CITY OF ALBUQUERQUE

January 31, 2018

RE: **Kidz Academy**
McMahon and Fineland NW
Grading Plan and Drainage Report
Engineer's Stamp Date 1/18/18 (File: A11D016)

TYP. ORIFICE PLATE DETAIL
N.T.S.

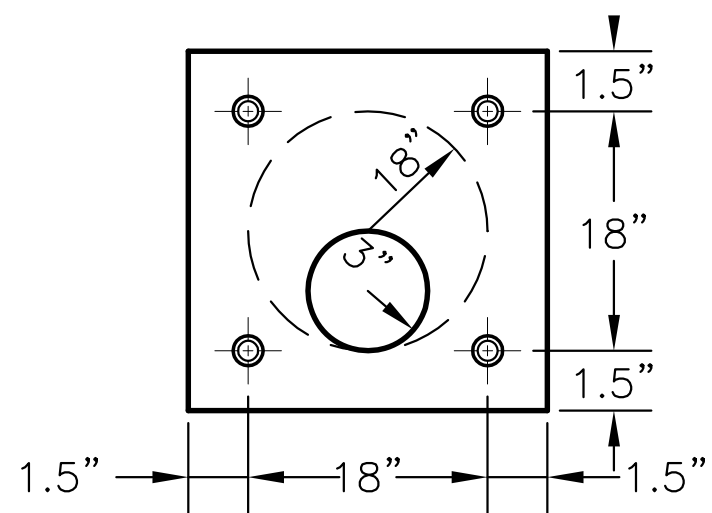
7. Please specify a square opening on the orifice plate.
8. Please label this Grading Plan as "conceptual, not for construction" or similar.
9. How is the roof drainage routing through a first flush/detention pond? The drains appear to be plumbed directly to the private storm drain. More detail is need on the ponds and storm drains to demonstrate that they will intercept flows and adequately restrict discharge from the site.
10. Quantify the volume of first flush bypass and state on plans. It appears there may be some bypass from the drive entrance, but it is unclear with the new ROW line.
11. This site has been graded several times and no land treatment A remains, Please update the proposed Hydrology to reflect.
12. There are two Basin C's on the subbasin map and no Basin A; Please correct.

ENGINEER'S SEAL  2/12/18 DAVID SOULE P.E. #14522	KIDZ ACADEMY GRADING AND DRAINAGE PLAN  1606 CENTRAL AVENUE SE SUITE 201 ALBUQUERQUE, NM 87106 (505) 872-0999	DRAWN BY WCWJ DATE 2-12-18 21801-LAYOUT-9-25-17 SHEET # JOB # 21801
---	--	---

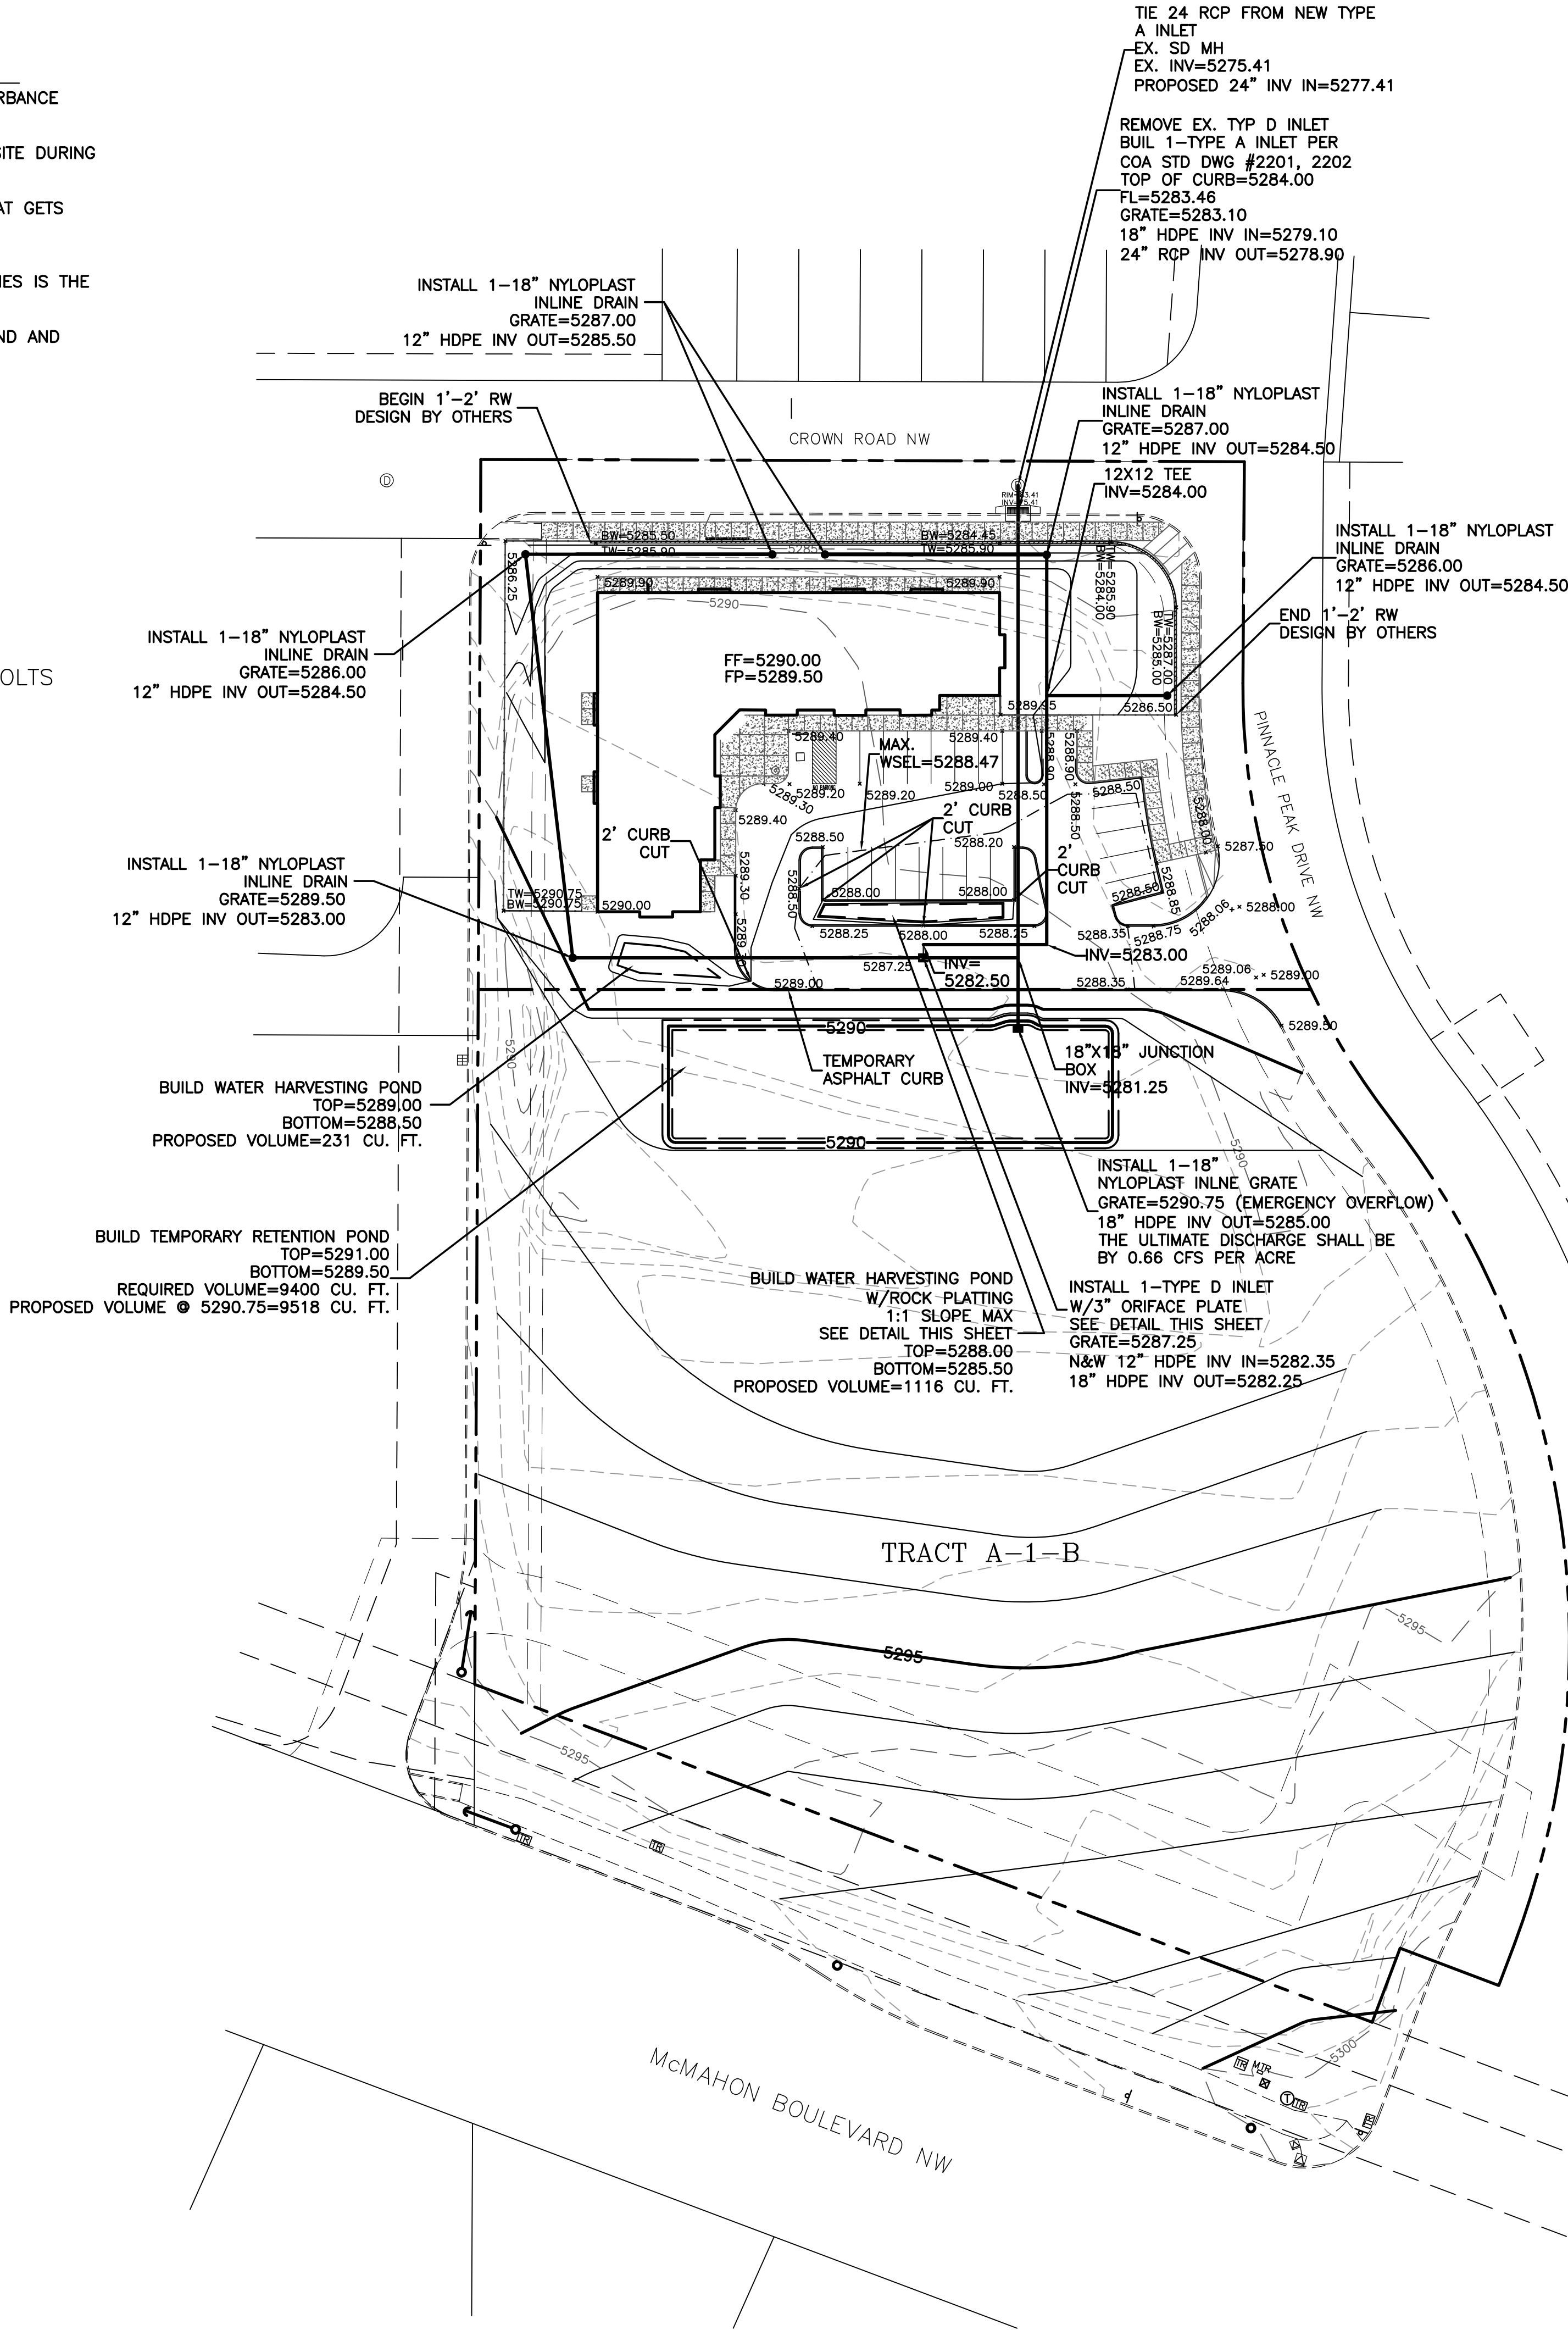
1. The current approved grading plan (Goodwin-2018) and the new plat allow blanket cross lot drainage to a new pond (not constructed) with zero discharge from this larger site. This plan will need to restrict upstream discharge from Lot A1B with a new pond on lot A1B restricting discharge to at least 1.3cfs/ac. A Drainage Covenant (no public easement) will be required for this pond and be granted by the owner of Lot A1B.

5. Provide RCP CL III pipe in the Crown Road ROW. There should also be an existing 18" RCP pipe with drop inlet coming from this manhole and onto the property; why not make use of that? This drainage connection will also need to be listed on the Infrastructure List.

6. Show the new lot lines on the grading plan, including the ROW takes for Crown and Fineland.
